Our Case Number: ABP-314724-22

Re: Railway (Metrolink - Estuary to Charlemont via Dublin Airport) Order [2022]
Metrolink. Estuary through Swords, Dublin Airport, Ballymun, Glasnevin and City Centre to Charlemont, Co. Dublin

Metro Link Railway Works Order Submission

16 January 2023

Drawing Title
Figure 9.5 St Stephen's Green in Relation to Other Public Transport Facilities
Sheet 14 of 15

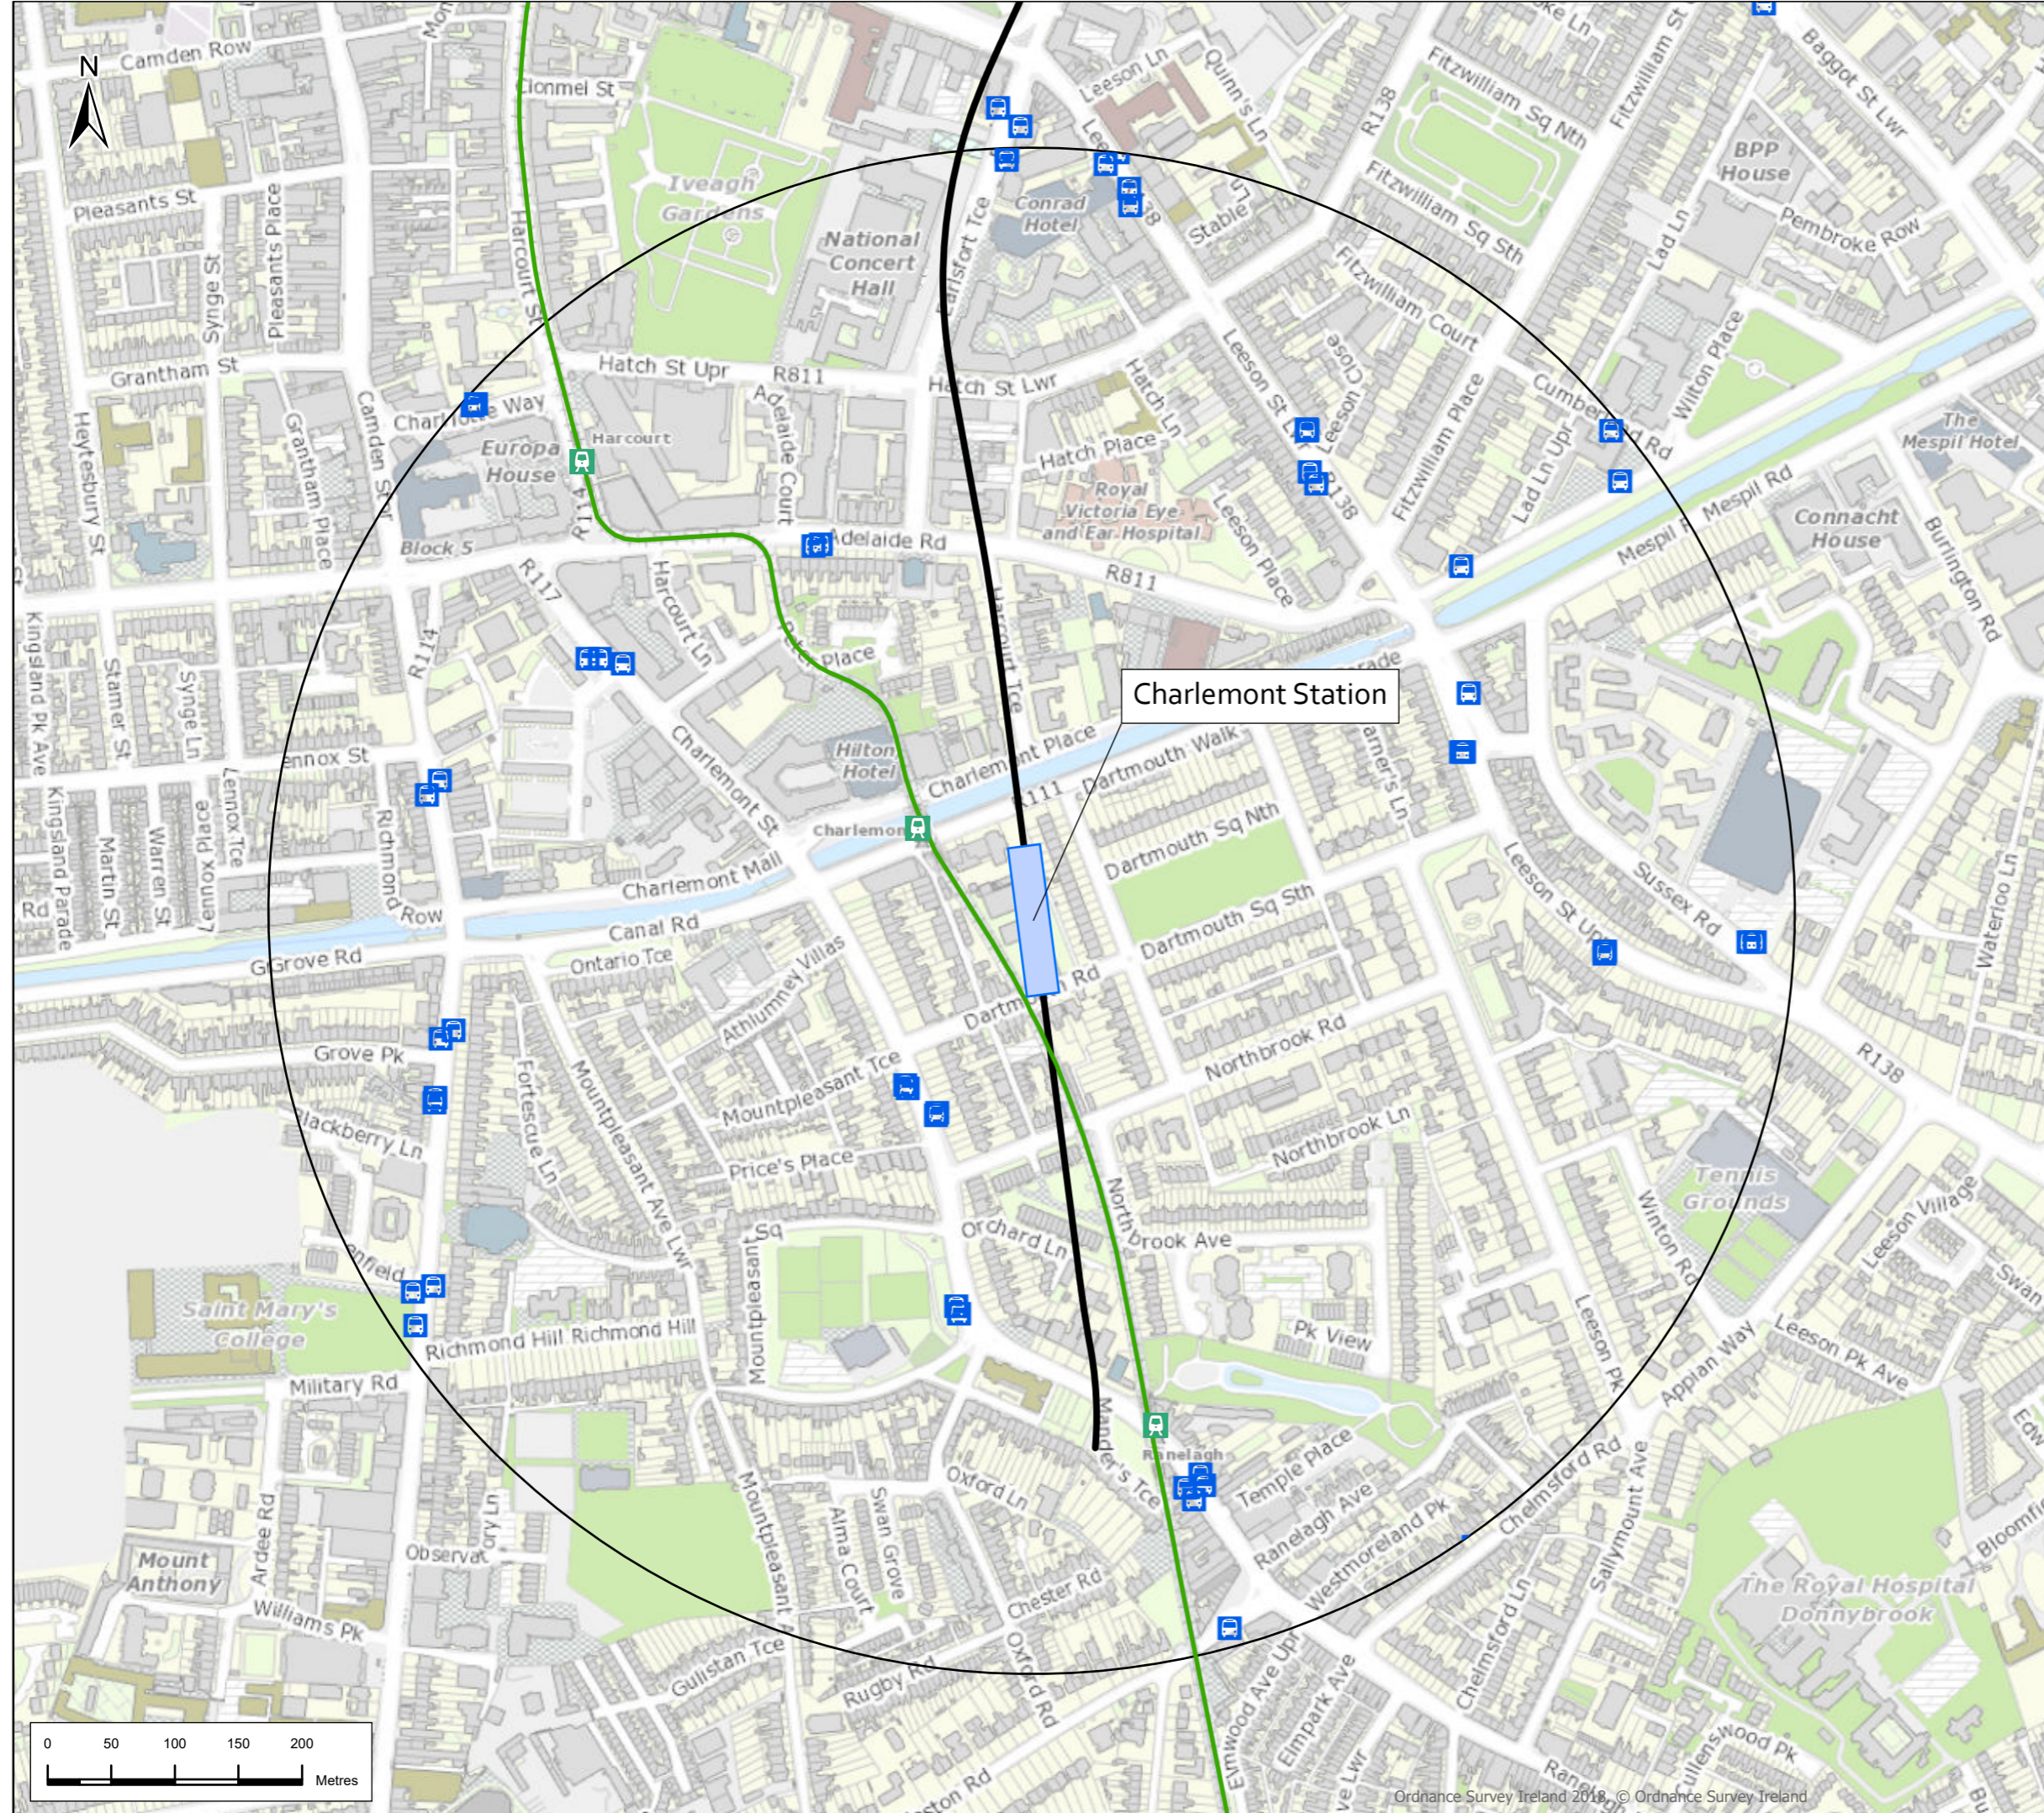
Single pedestrian entrance is insufficient given significant demand from Lesson Street end, a second entrance should be provided. It's confusing that Charlemont gets two entrances yet St Stephens Green which clearly will have a greater flow of passengers has only one.
